Arun District Council
Arun Civic Centre
Maltravers Road
Littlehampton
West Sussex BN17 5LF
Planning & Building Control General Enquiries
Tel: (01903) 737756 Fax: (01903) 730442
Dx: 57406 Littlehampton
Minicom: 01903 732765
e-mail: planning@arun.gov.uk
website: www.arun.gov.uk/planning

Application No: FG/37/22/PL
Site Address: 61 Sea Lane Gardens Ferring BN12 5EG
Description of works: 1 No dwelling. This site is in CIL Zone 4 and is CIL Liable as new dwelling.

Thank you for your internet representation made on 7th April 2022 which has been recorded as an objection with the comments as follows:

Client:		
Address of Works: 61 Sea Lane Gardens Ferring West Sussex BN12 4TB		
Drawing Title: Proposed Dwelling Planning		
Paper Size: A3	Date: Dec. 2021	
Job Number: AR-165B	Drawing Number: 01	Revision: Revision

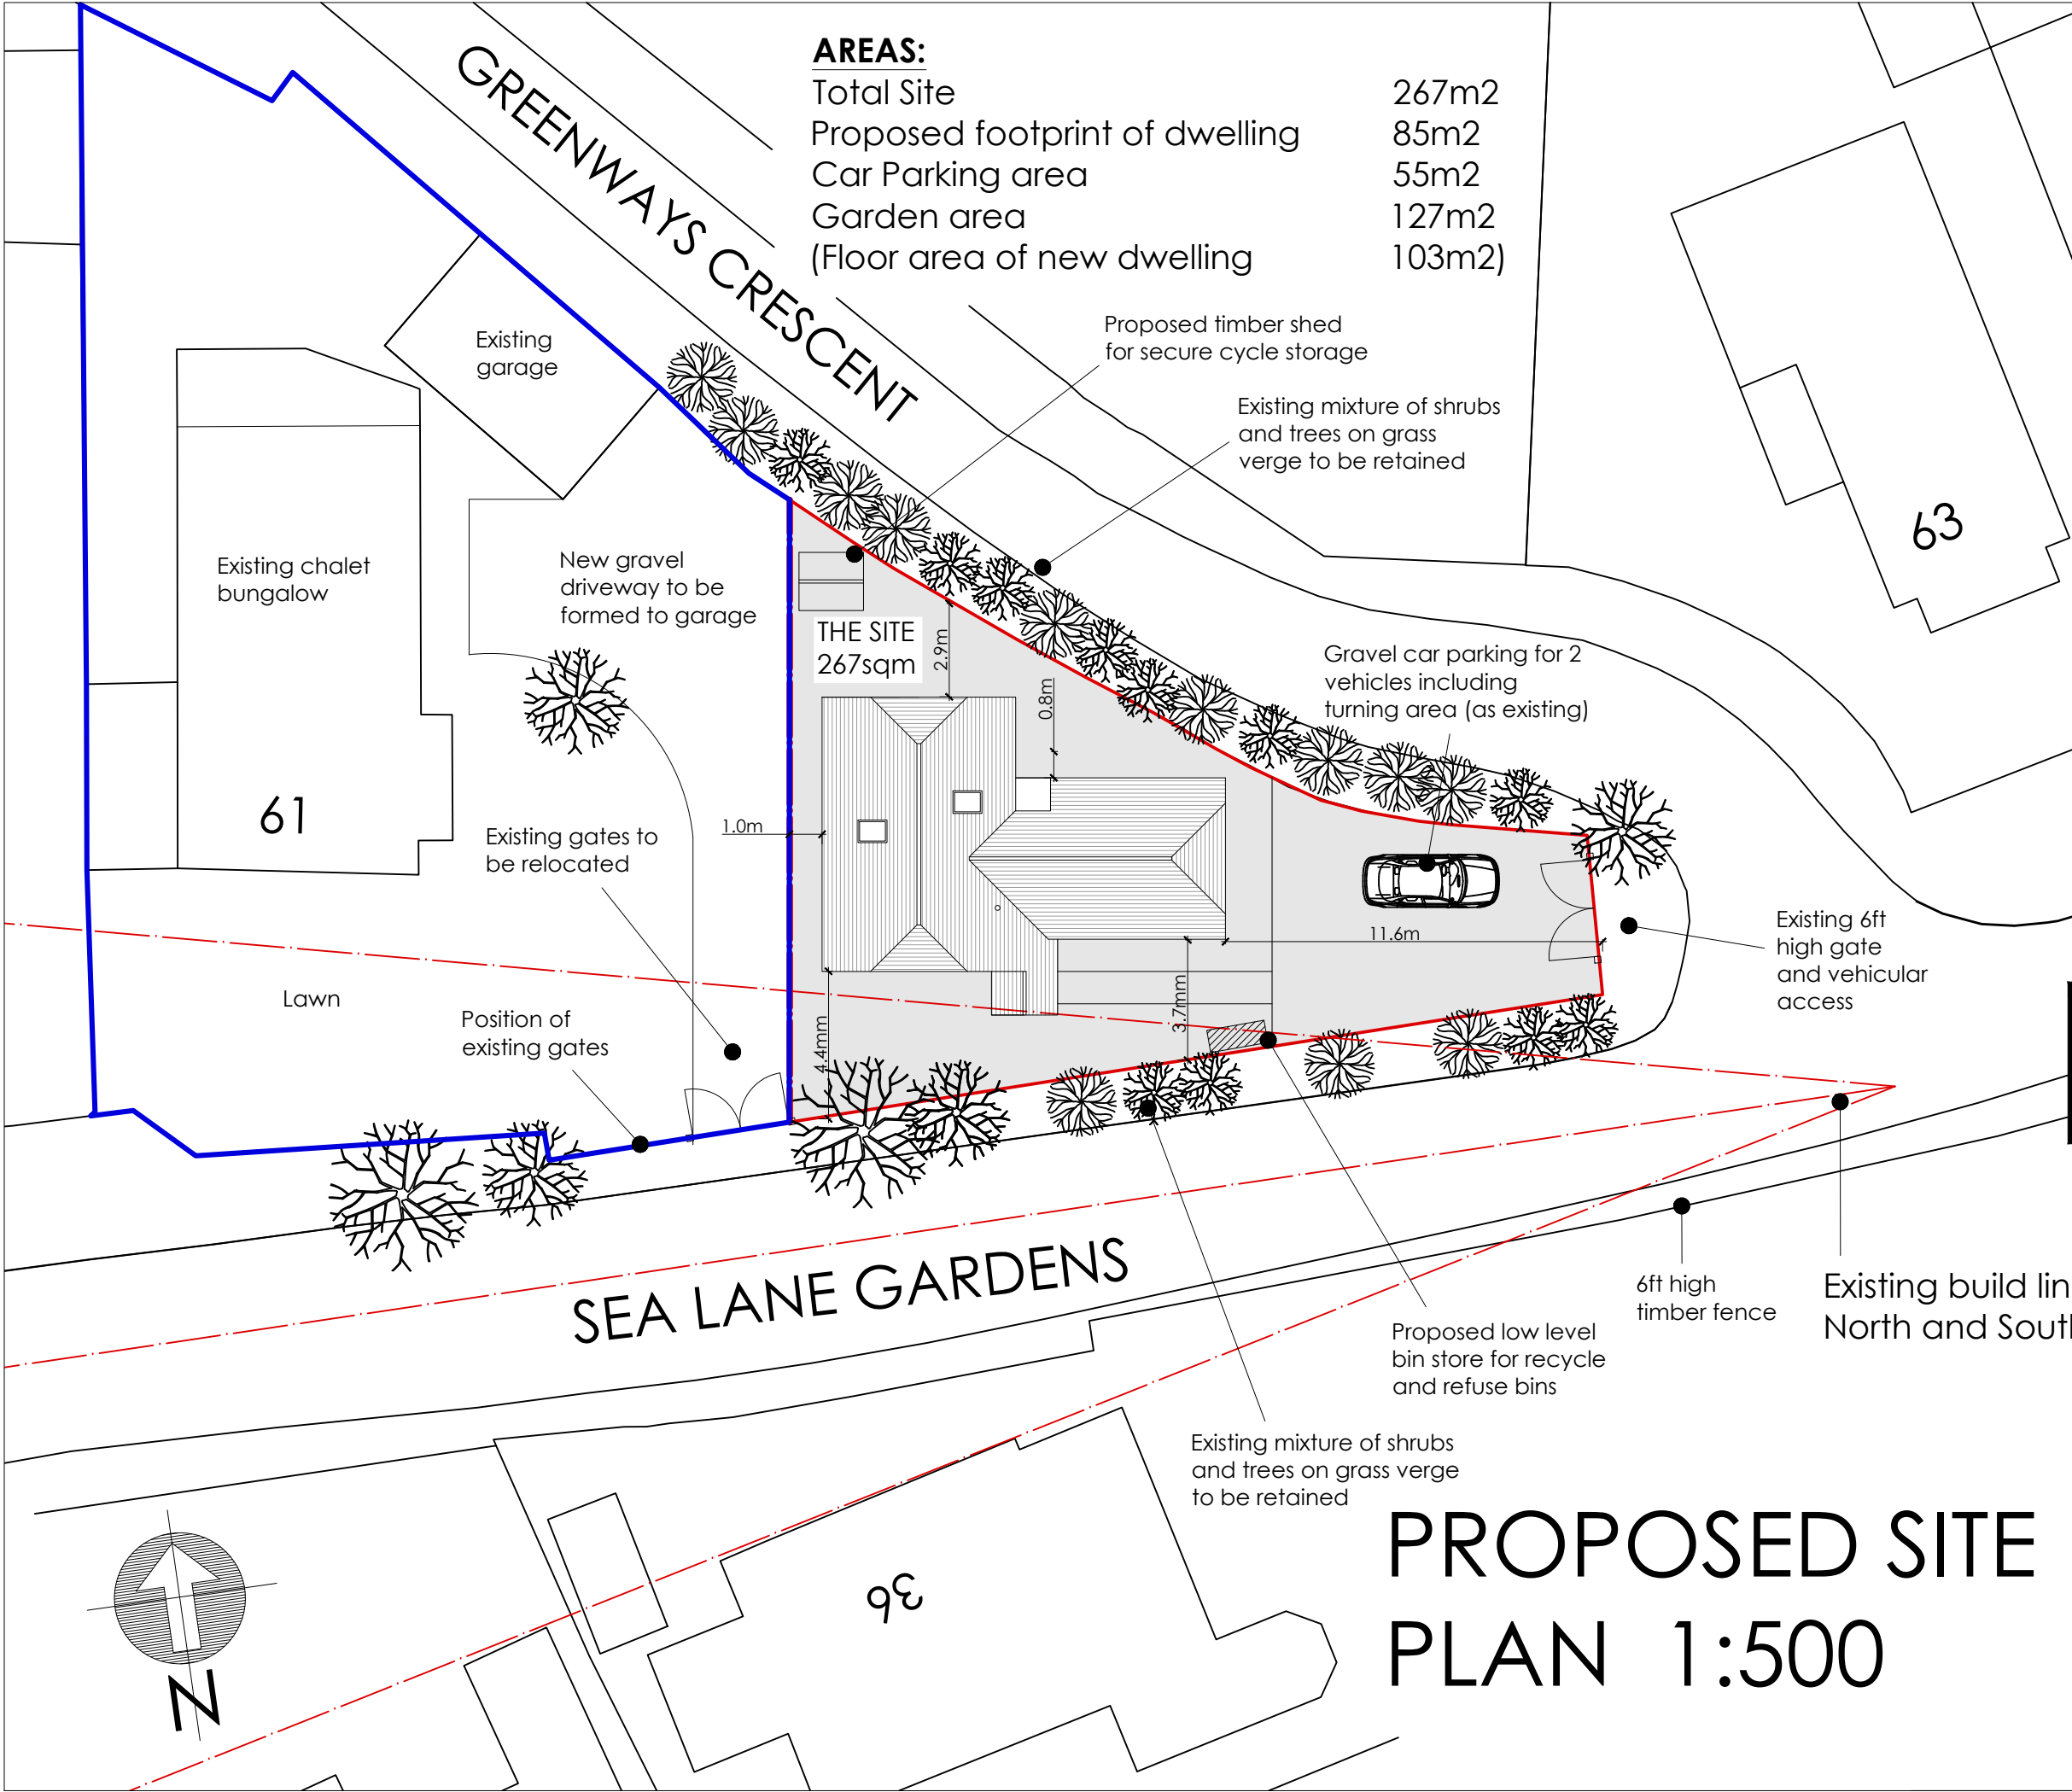
1. Road safety out of Greenways crescent onto Sea Lane Gardens, this is already a dangerous junction to exit from and further traffic exiting onto the road from 61 increases the possibility of collision with pedestrians, cars and cyclists. The existing plans show that the entrance to the new build will further encroach onto the narrow entrance for Greenways crescent. Also there is a further danger as there are no pavements on either roads and no street lighting.

3. Boundaries for the site appear to encroach onto Greenways crescent which is already a narrow road with no pavements and loss of protected trees is also a concern.

# PROPOSED CAR PARKING PLAN 1:50

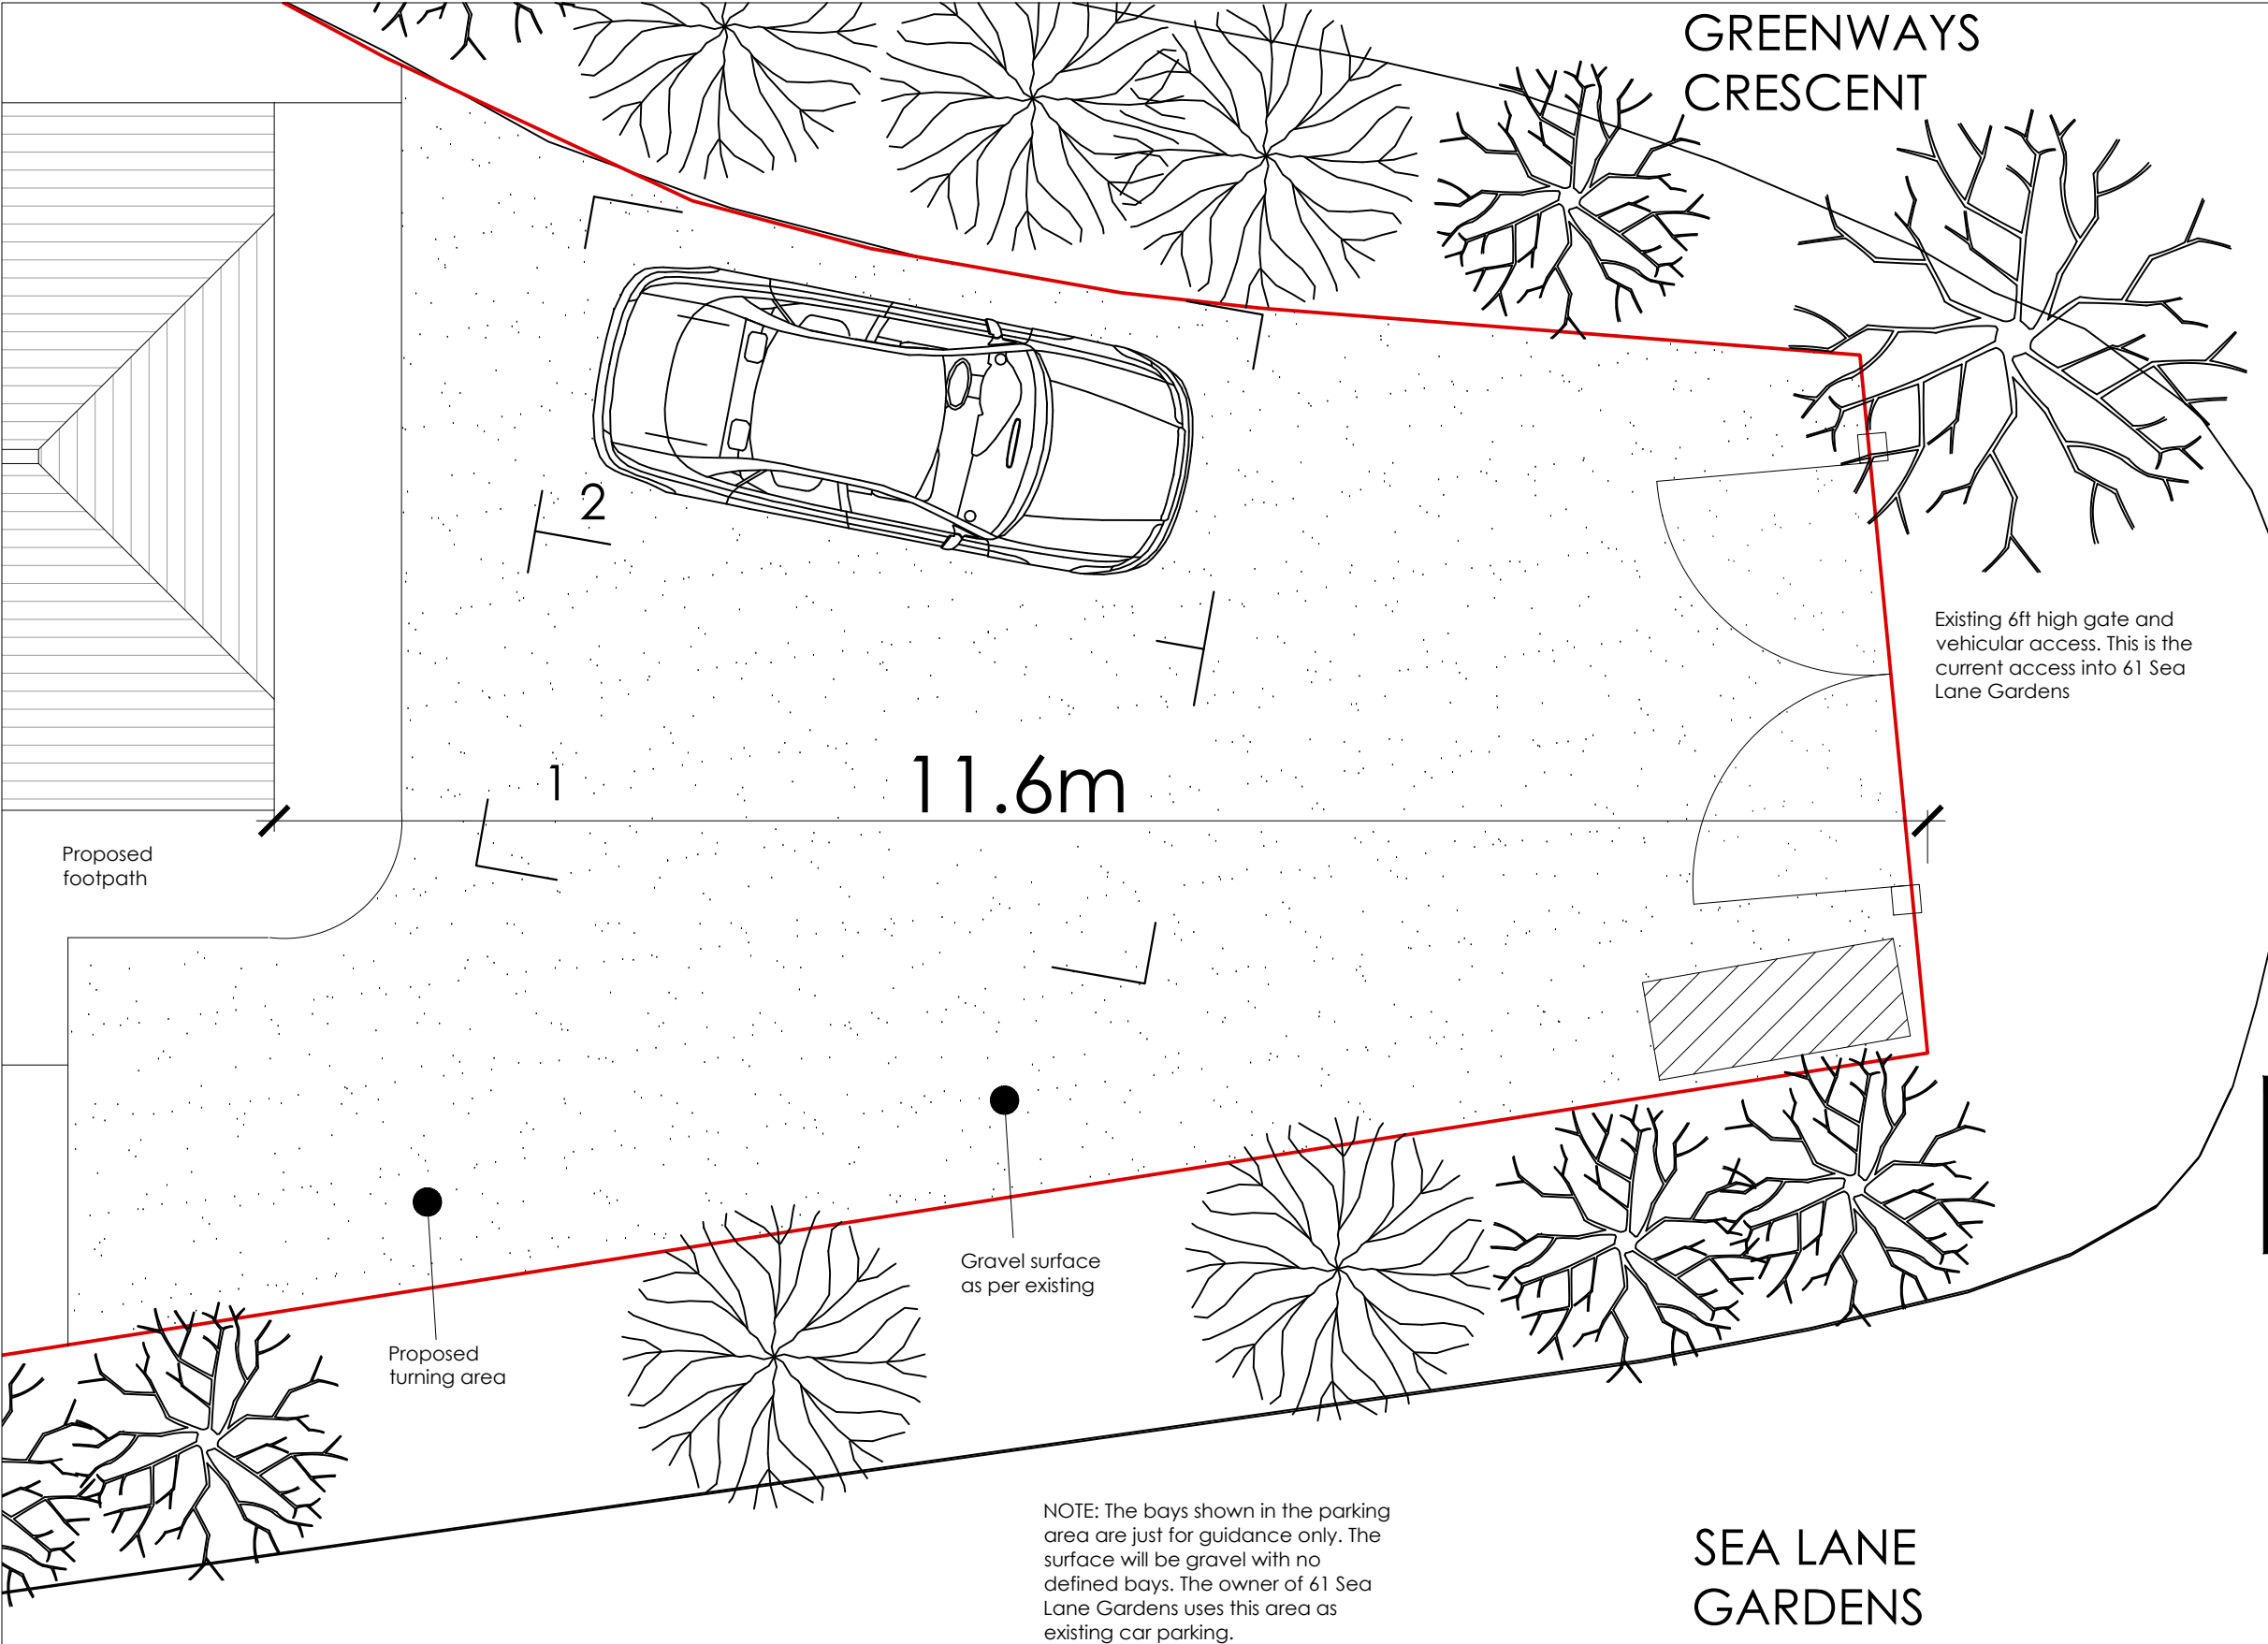
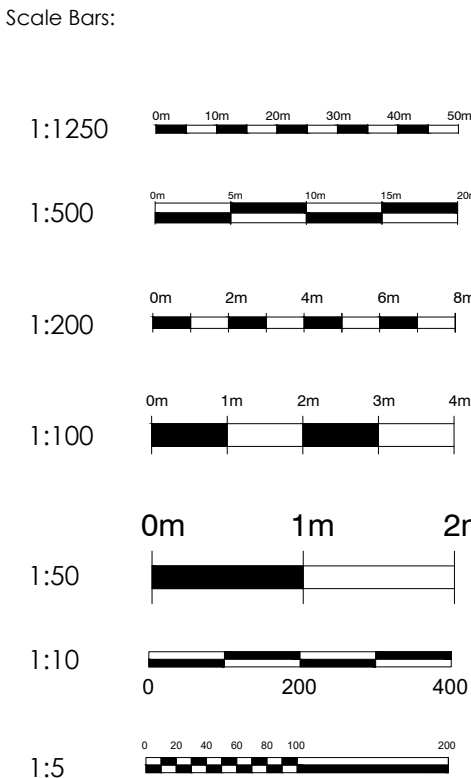
Access into Greenways crescent for vans and lorries is already difficult for residents and a further development would increase this problem.
